Storm Water Management Plan

I68 Training Facility

PCD File Number: **PPR2440**

EPC STORMWATER REVIEW COMMENTS
IN ORANGE BOXES WITH BLACK TEXT

MVE PROJECT 61224  
MVE DRAWING GRADING PLAN

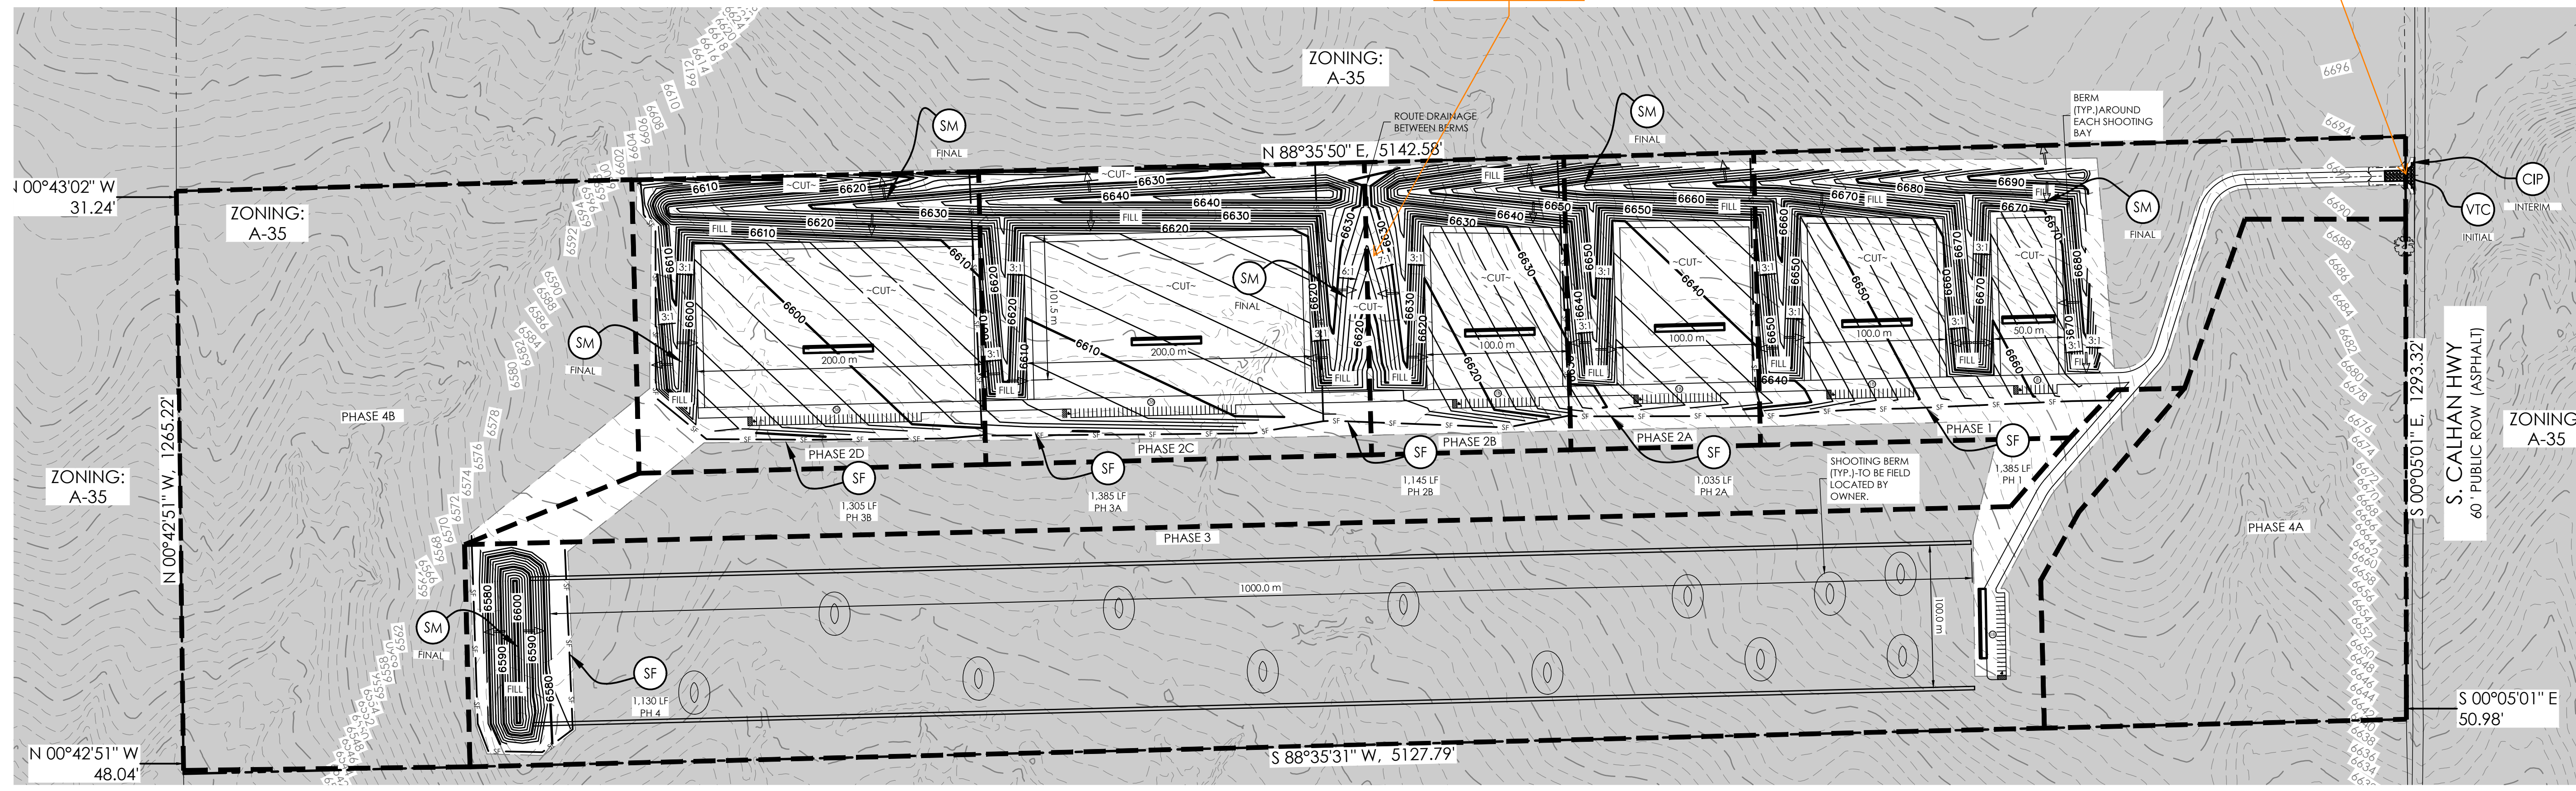
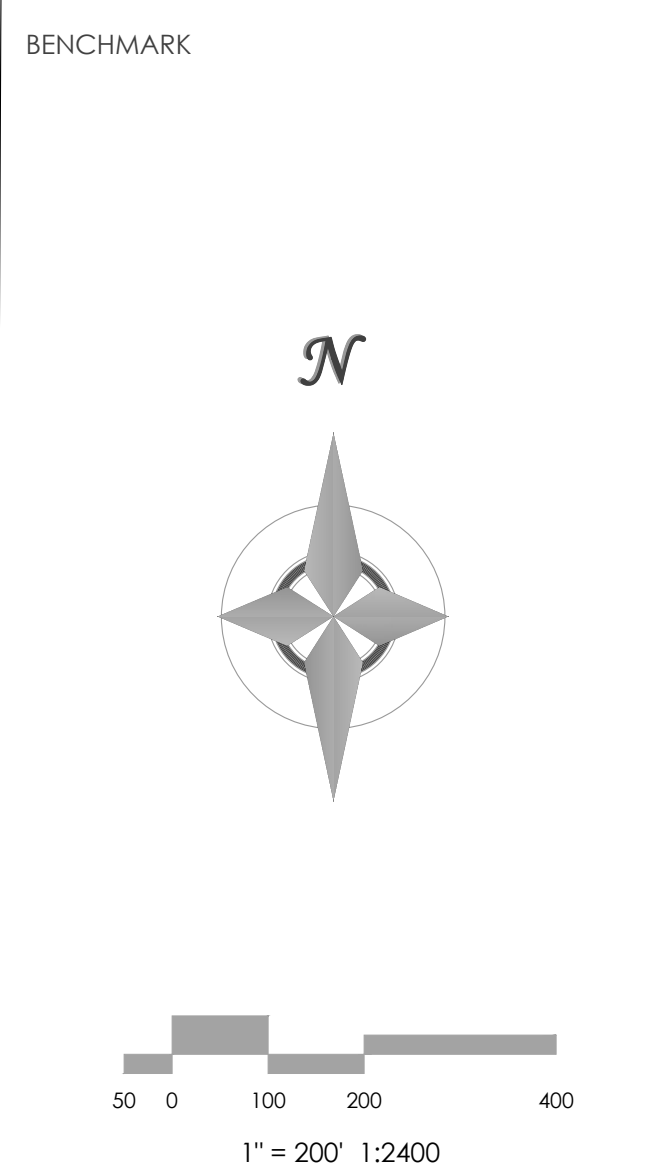
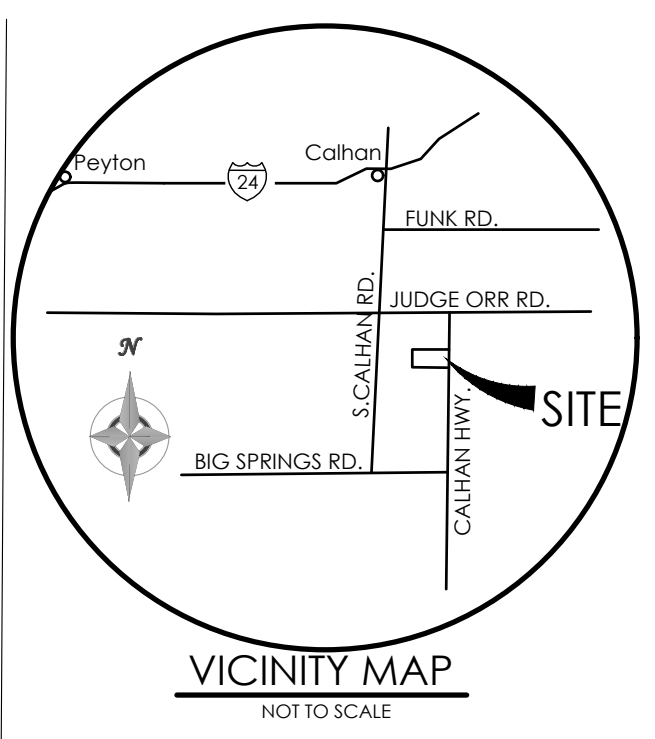
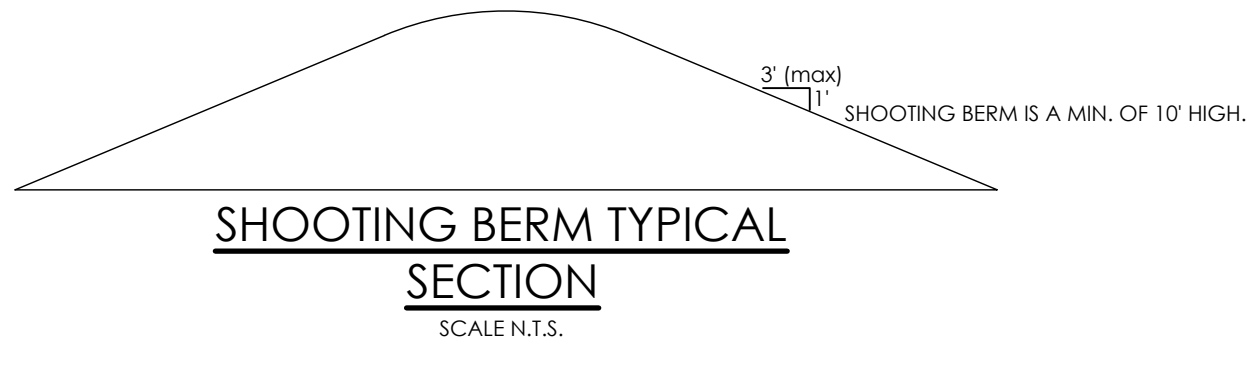
GEC Plan is a "living document" and must be amended throughout the life of the project to show all CMs

GEC Plan is a "living document" and must be amended throughout the life of the project to show all CMs
